From: [Oliver Waring](#)
To: [David Elmore](#)
Cc: [Planning Comments \(Shared Mailbox\)](#)
Subject: 6/2019/2571/VAR 101 Brookmans Avenue, Brookmans Park, AL9 7QG
Date: 14 November 2019 12:05:50

I have taken a look at the revised plans and it looks like the only change, landscape wise, is the extension of the driveways which reduces a small amount of landscaping by the fronts of plot 3, 4 and 5. This is consider a minor amendment and will have no overall impact in the landscape.

Client: Seqoya	Site: 101 Brookmans Avenue, Brookmans Park		
Scale: 1:200 @ A1	Date: 15/02/2019	Drawn: GP	Approved: CX
Drawing Title: LANDSCAPE MASTERPLAN	Drawing No: 1903-GUA-DR-L-001	Revision: P02	A

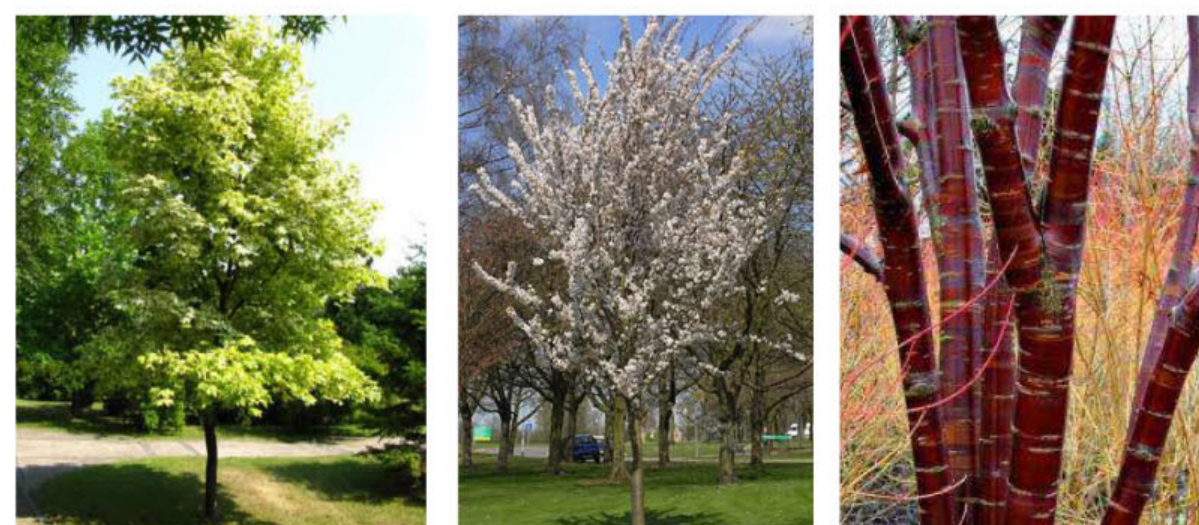
There is no objection to the variation on landscape grounds.
